**Consultation Response from KC,
Highways Development Management**

2022/91188 100, St John's Road, Birkby, Huddersfield, HD1 5EY

Erection of single and two storey side and two storey rear extensions to increase ground floor retail unit and HMO above (within a Conservation Area)

Date Responded: 15/06/22

GROUND FLOOR PLAN

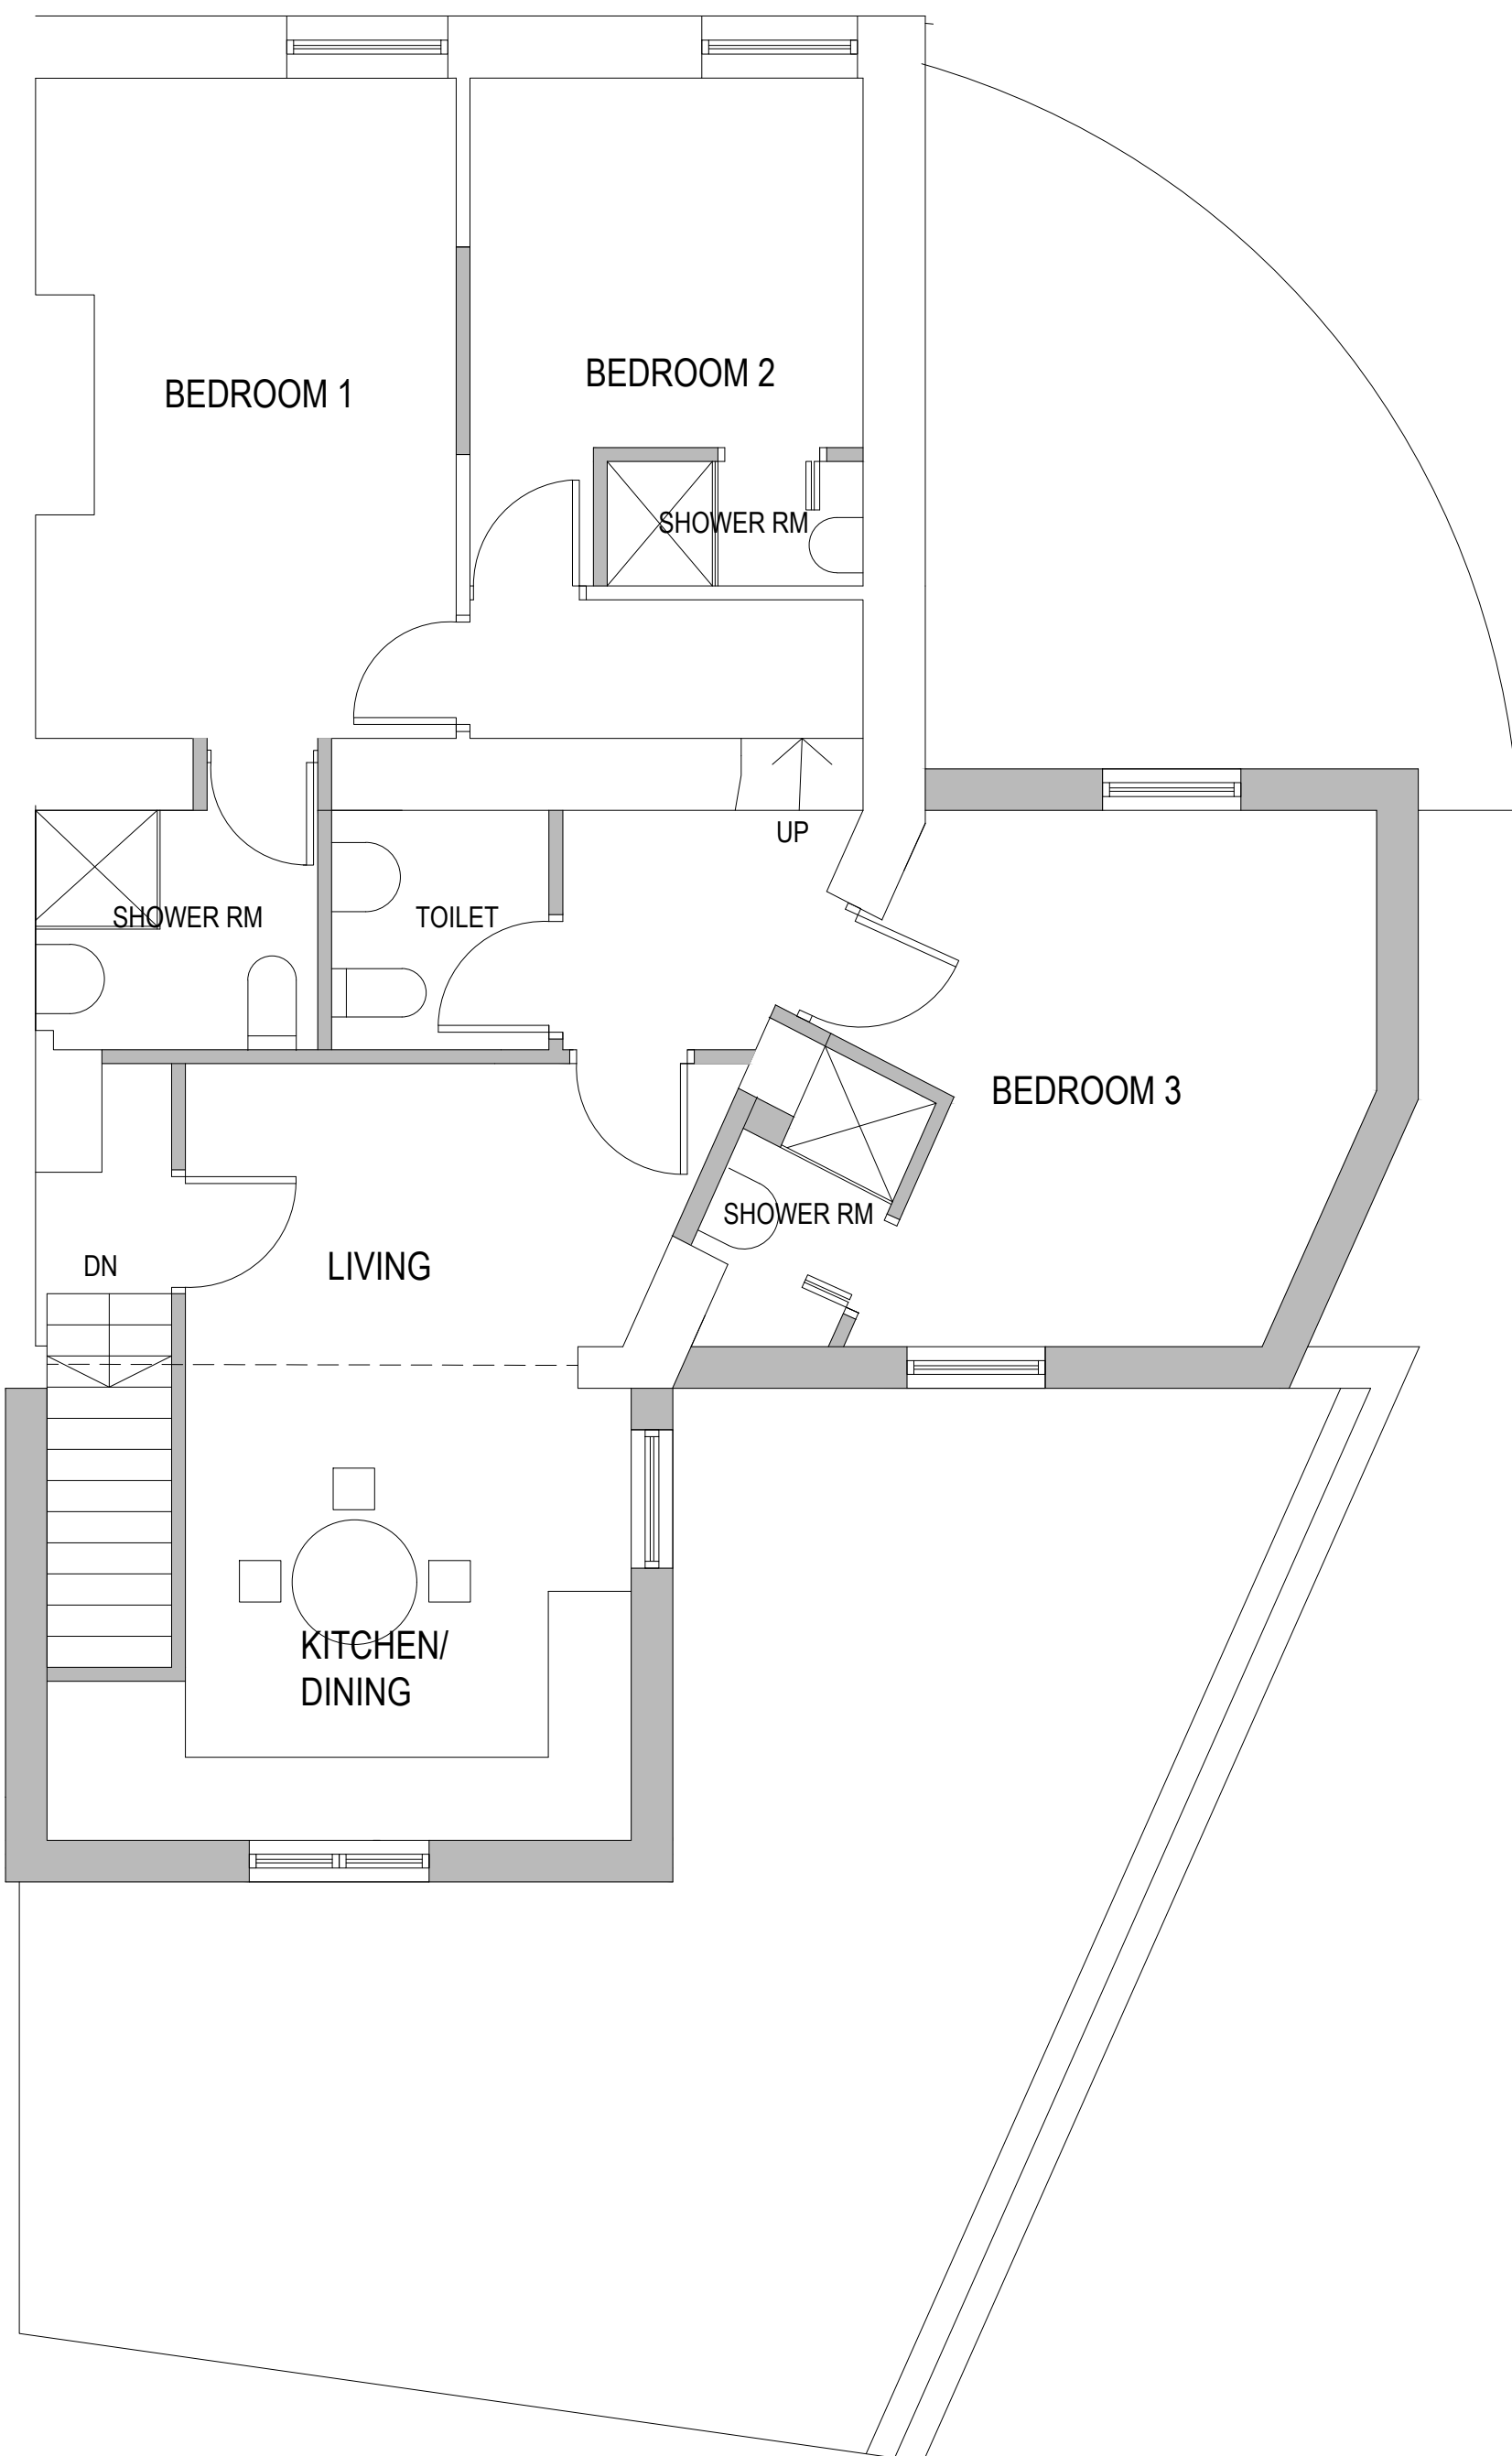
Drawing No 02 shows the location of a bin store, but this is behind the parking area and so would not be accessible for a collection crew and so we would like to see a collection presentation point marked clearly on the drawing, this should be where it is accessible to a collection crew but not where it would obstruct the access to the parking/deliveries space or the highway/footway for road safety reasons. This should be conditioned.

Before development commences, details of suitable storage, bin presentation points and access for collection of wastes from the premises hereby approved shall be submitted to and approved in writing by the Local Planning Authority. The approved details shall be provided before first occupation and shall be so retained thereafter.
